Engineers Comments Regarding Surface Water Drainage

Application Reference:	Y/10/26/PL	Reviewer Reference:	ADC/EXT5/AF
Planning Officer:	Kathryn Welch	Date of Review:	13/04/2026
Site Name:	Rookery Farm Flansham Lane Felpham PO22 6EP		
Application Description:	Partial demolition of agricultural building and erection of 1 No dwelling. This application is a Departure from the Development Plan and is in CIL Zone 3 and is CIL Liable as a new dwelling.		
Assessment Number:	1

2601_200_PL0
*** PROPOSED DRAWINGS**

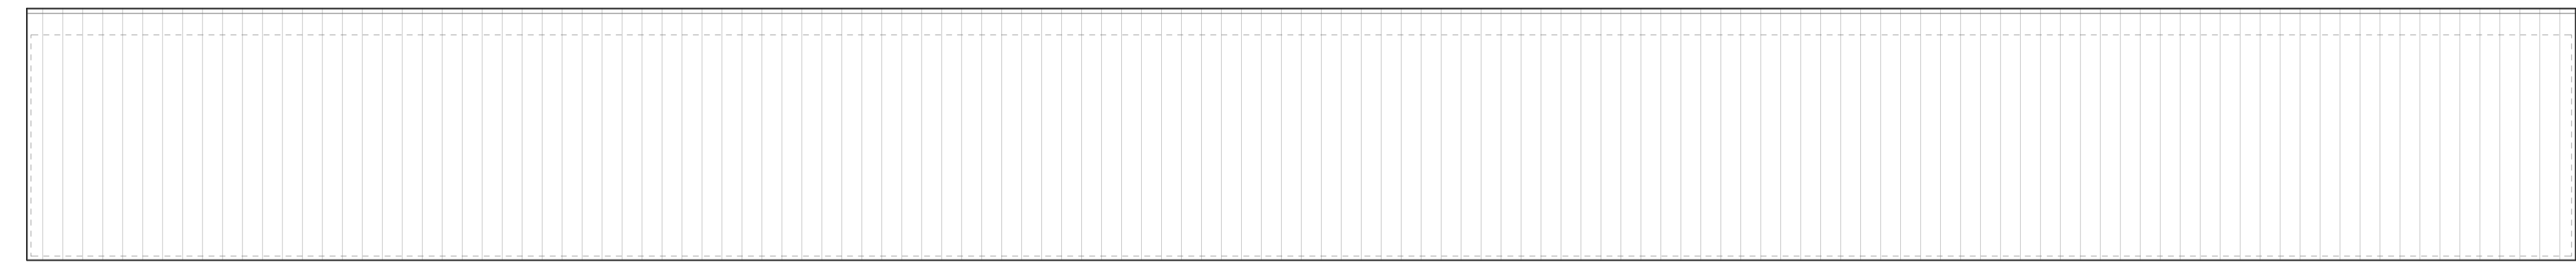
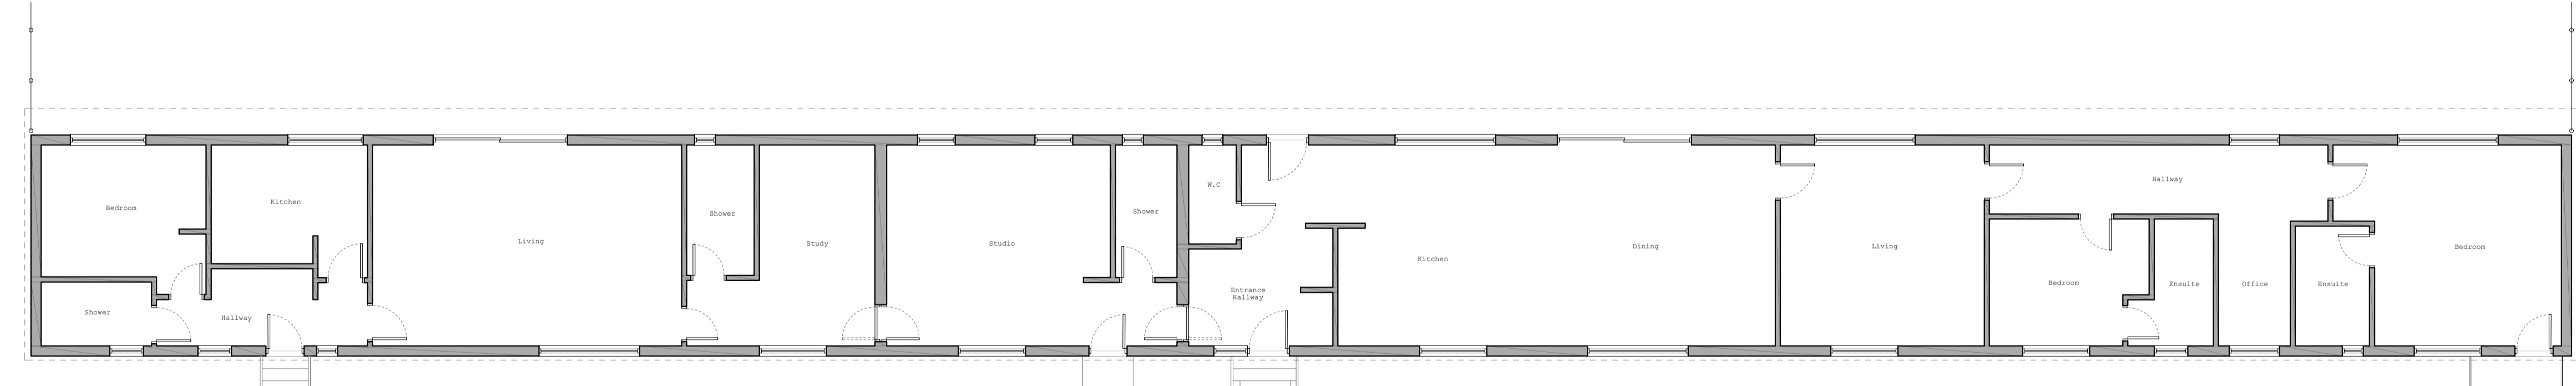
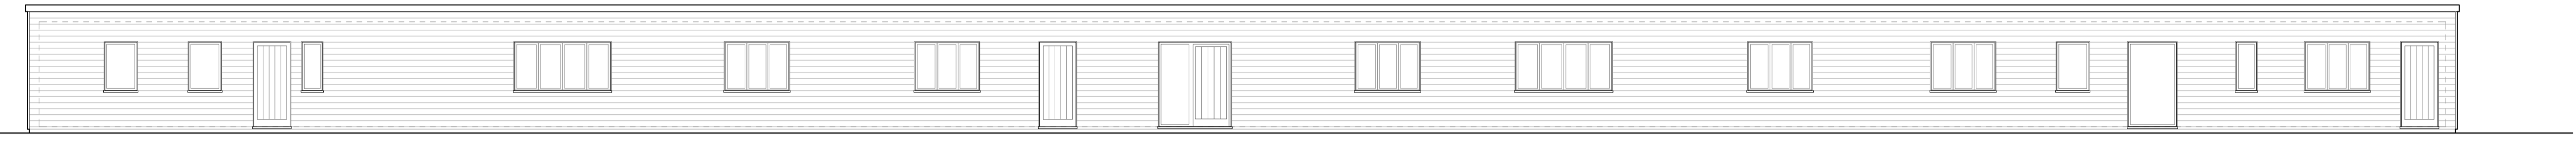
- 1.1. The drainage plan indicates rain water harvesting tanks to provide collection for non-potable reuse of rainwater. This can be clarified as part of a technical design to discharge a planning condition.
- 1.2. The proposed method of discharge is to discharge to ground but the submission does not provide ground investigation to demonstrate this is method is feasible.
- 1.3. Guidance on ground investigation to support proposals to discharge to ground via infiltration is provided on Arun DC web pages here: <https://www.arun.gov.uk/surfacewater>.
- 1.4. The runoff destination is not currently in accordance with the requirements of the NSfS Standard 1. Therefore, we **object** to the application
